Application No: FP/70/21/PL
Site Address: Kenwood Court 6 The Midway Felpham PO22 7EZ
Description of works: Erection of a car port and rearrangement of existing parking spaces. This application is in CIL Zone 4 (Zero Rated) as other development.

Thank you for your internet representation made on 19th May 2021 which has been recorded as an objection with the comments as follows:

**PROPOSED CAR PORT
PLANS AND ELEVATIONS**

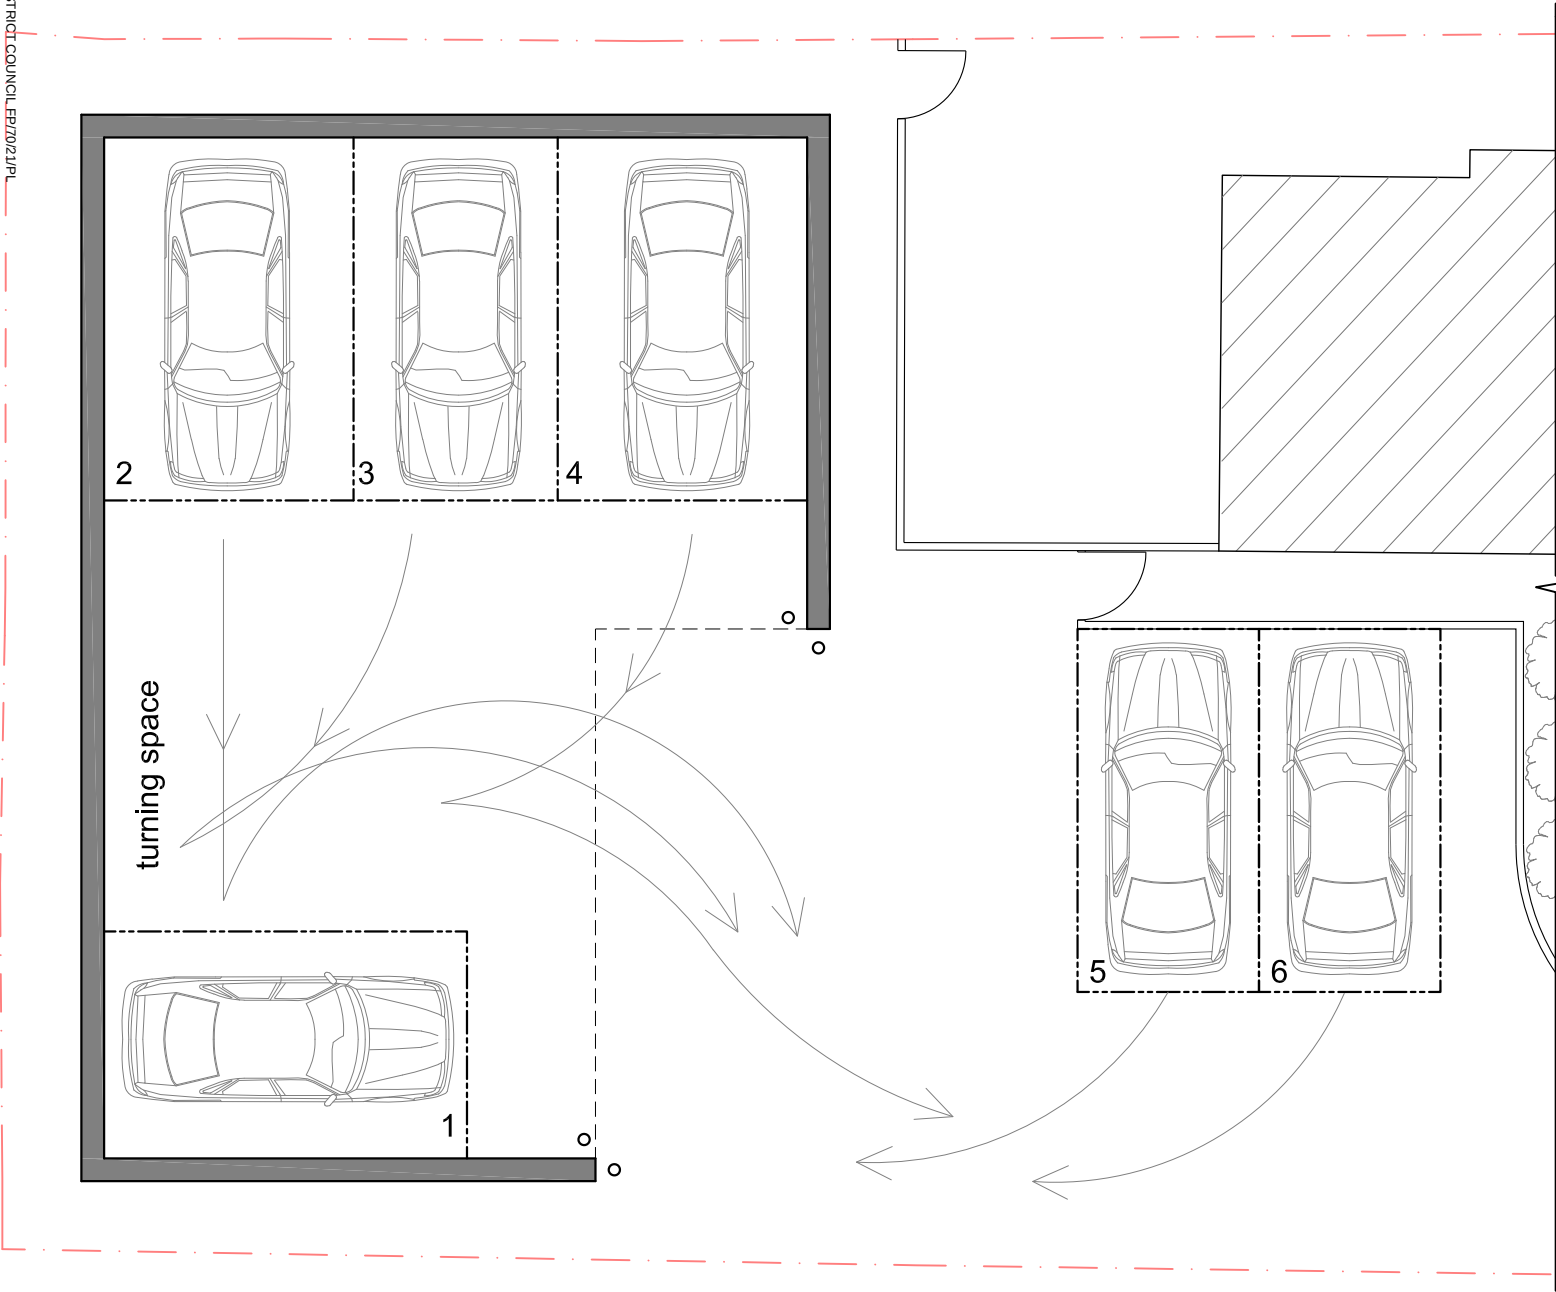
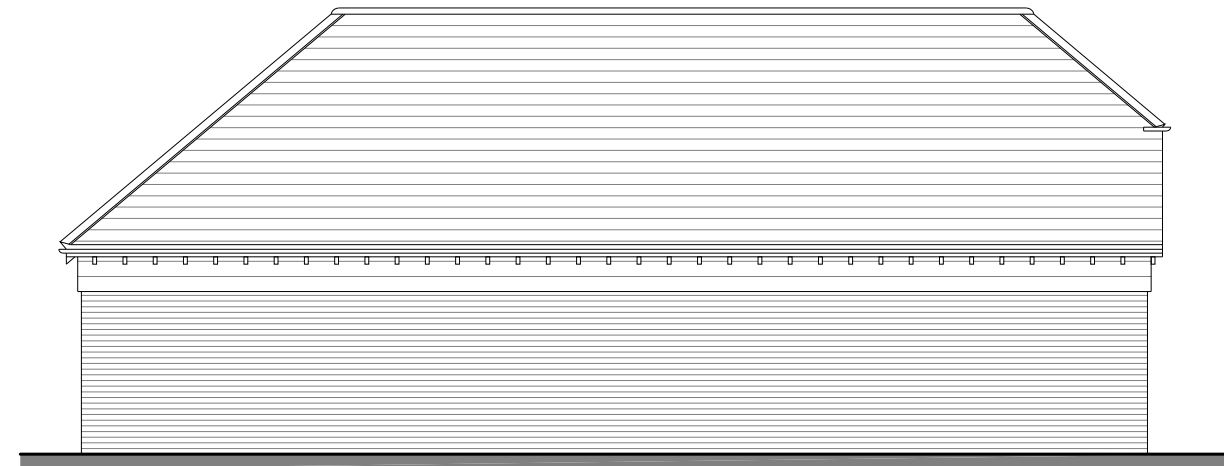
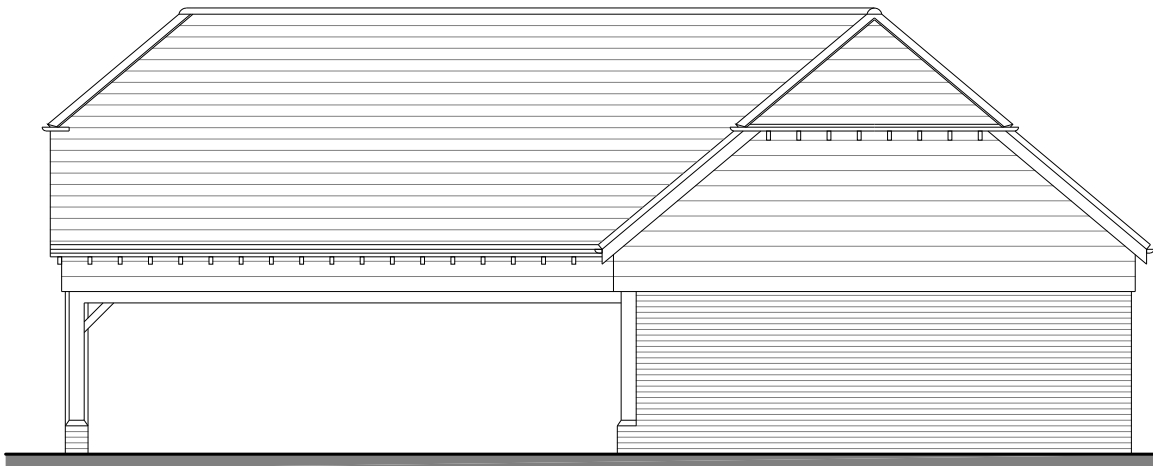
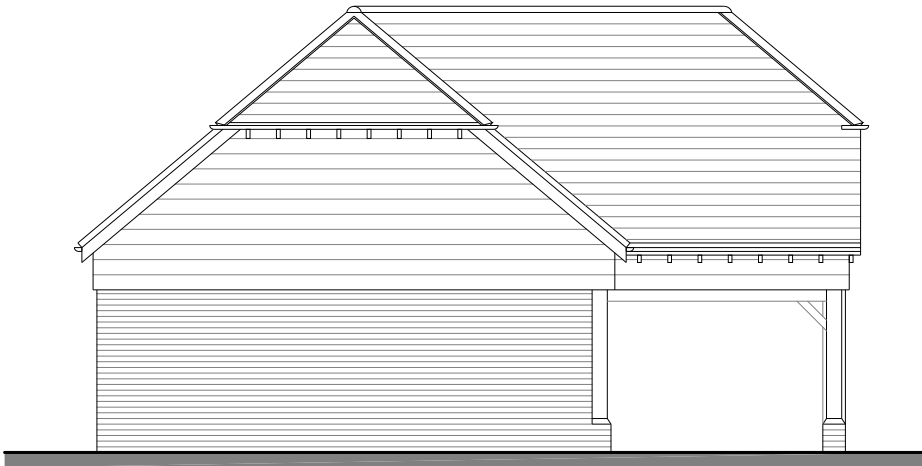
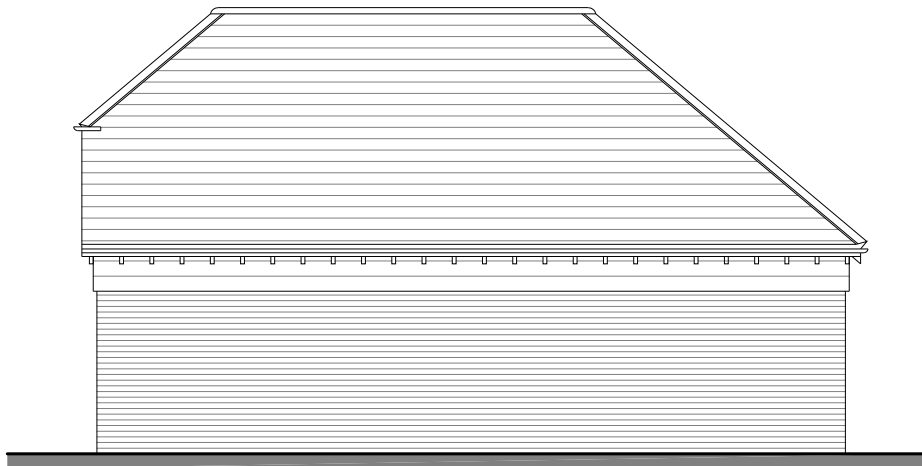
I live in a neighbouring property and having raised an objection to the size of the structure in the previous planning application for this property I see that the new submission is even bigger. Whilst there is no definitive scale on the proposed drawings I estimate the structure to be in excess of 6m meaning the projection would dominate the skyline and would be totally out of kilter with the neighbourhood scene. A structure of this size is considered an unneighbourly addition to the plot and in my humble opinion looks very much like the prequel to a future property development; the proposal as it stands cannot be supported in any way.
